From: Laura Gibbons
Sent: 02 September 2021 14:57:46
To: Maria Tomalova
Cc: Planning.Responses; Sarah Burrow
Subject: RE: 40 Elm Grove, Barnham BN/95/21/DOC

From: Maria Tomalova <Maria.Tomalova@arun.gov.uk>
Sent: 09 August 2021 17:57
To: Tom Wild <[REDACTED]>
Subject: BN/95/21/DOC

The document supplied on the most part seem acceptable, however I would appreciate the following clarifications and adjustments before I recommend discharge of Condition 6.

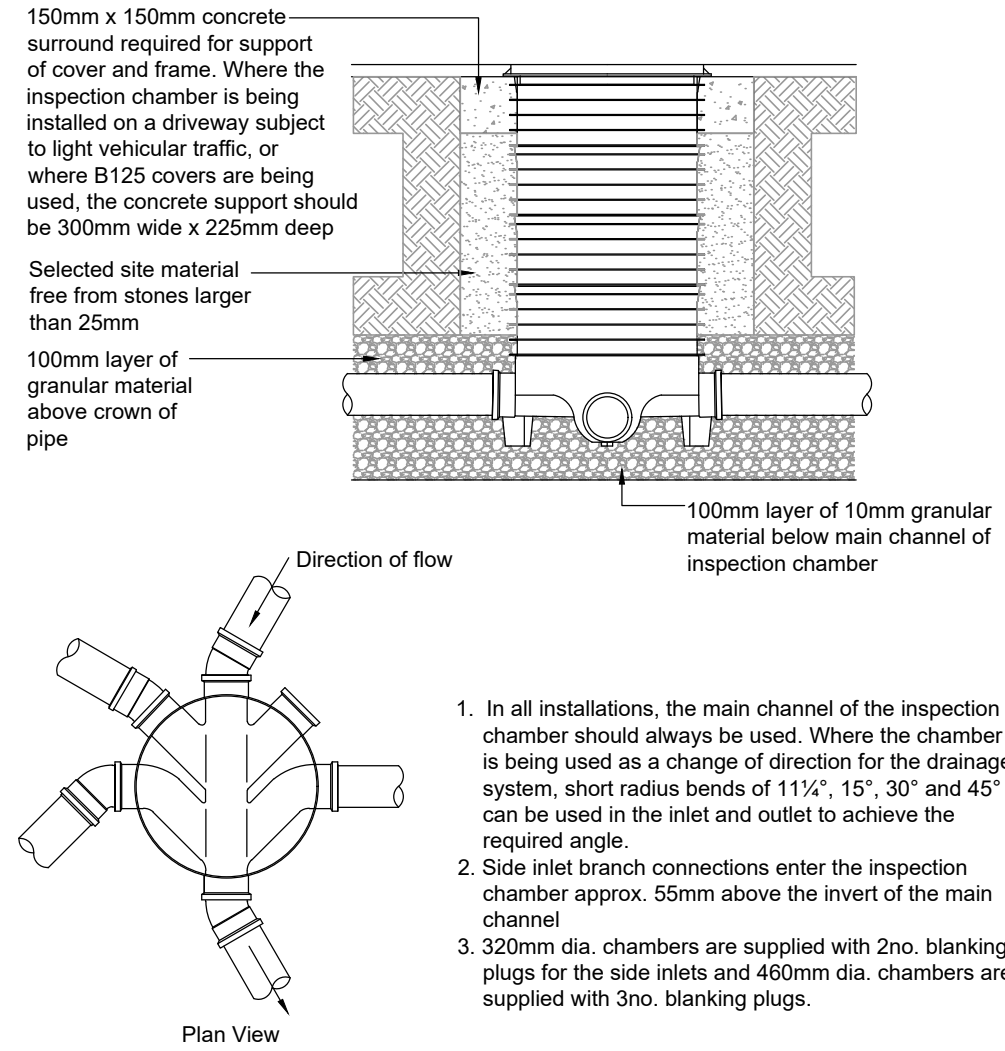
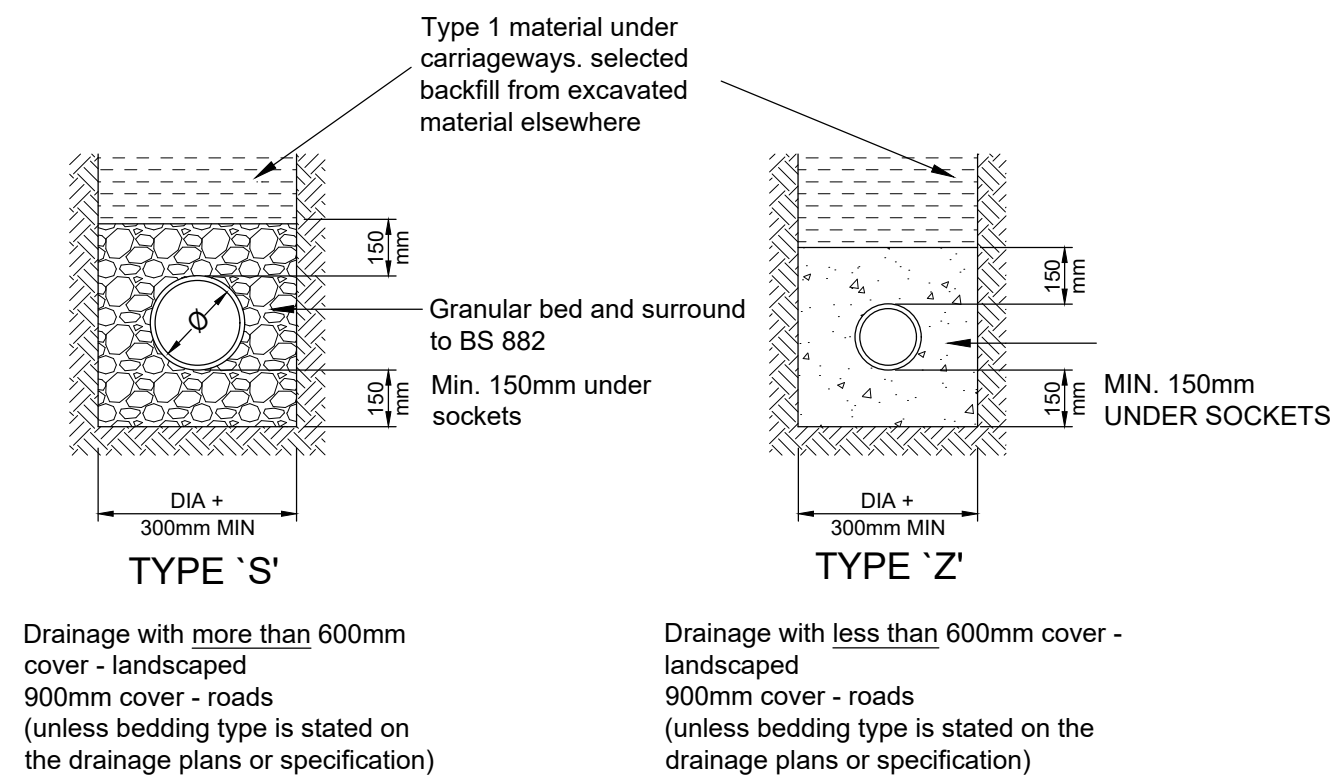
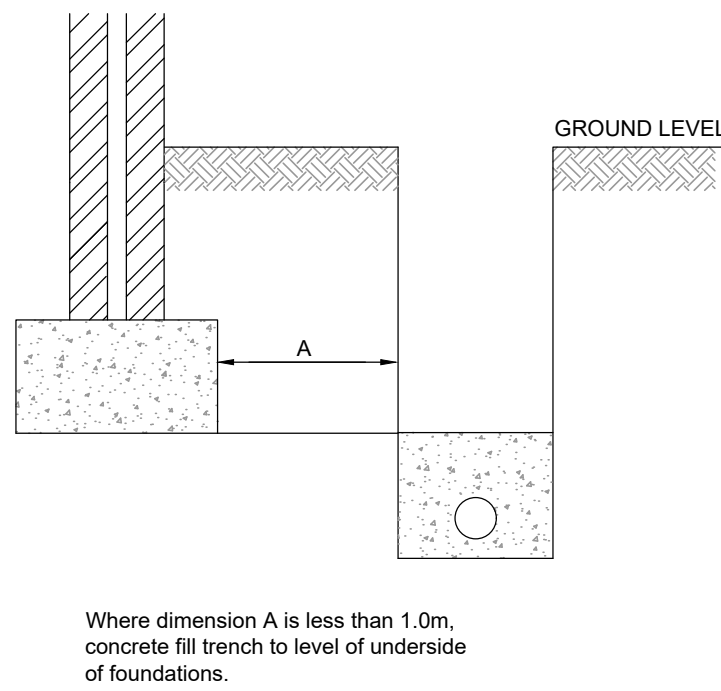
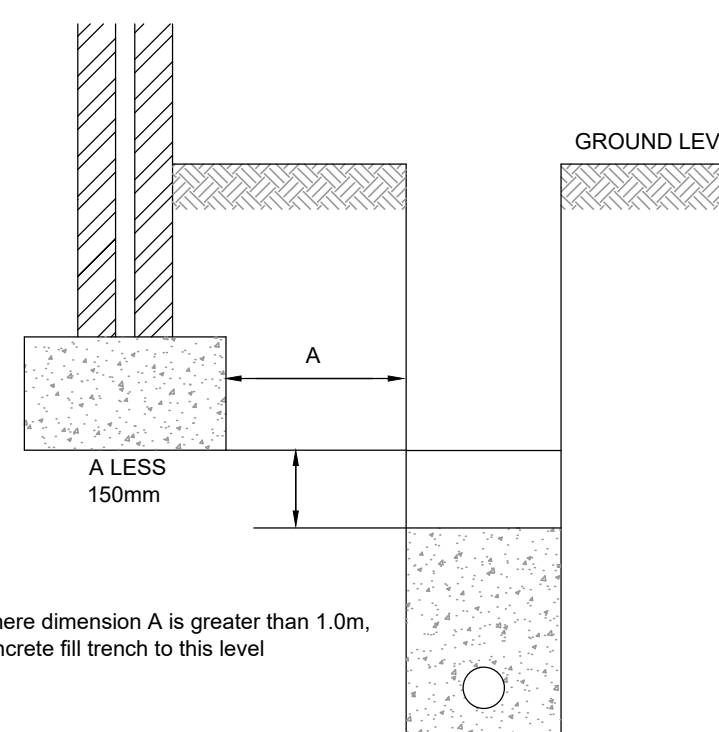
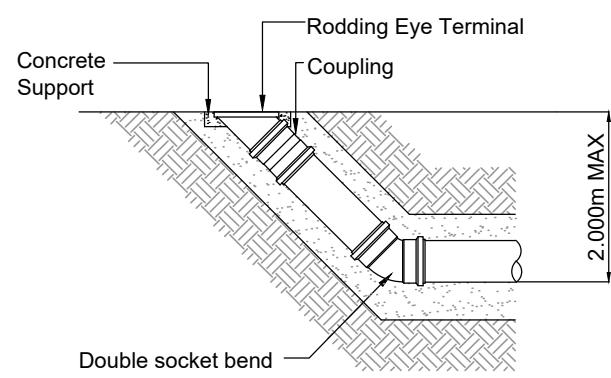
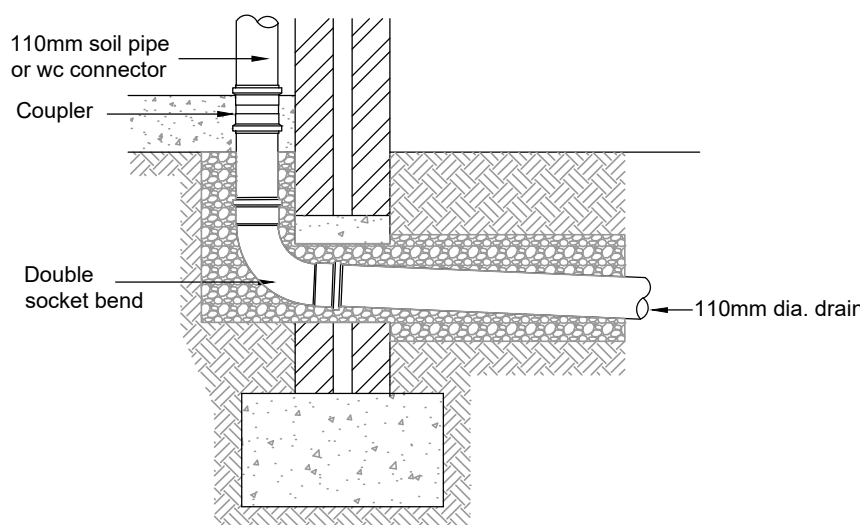
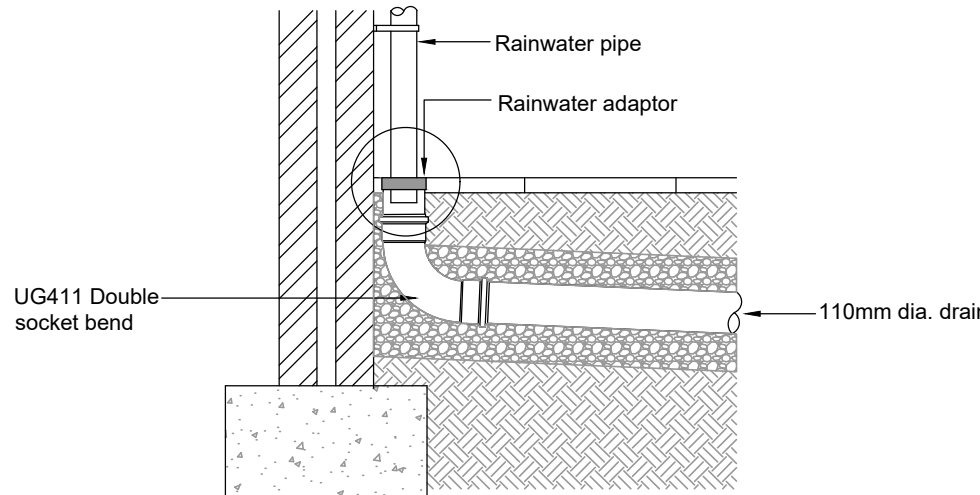
- 1. Please can you confirm the impermeable area used for the calculations. We would normally expect an impermeable area plan, however noting this on the layout should be sufficient as it is the whole dwelling.
- 2. Please can you adjust the pipe junctions on the western side of the dwelling so that they are angled in the direction of flow. Please also include a detail of the pipe junctions.
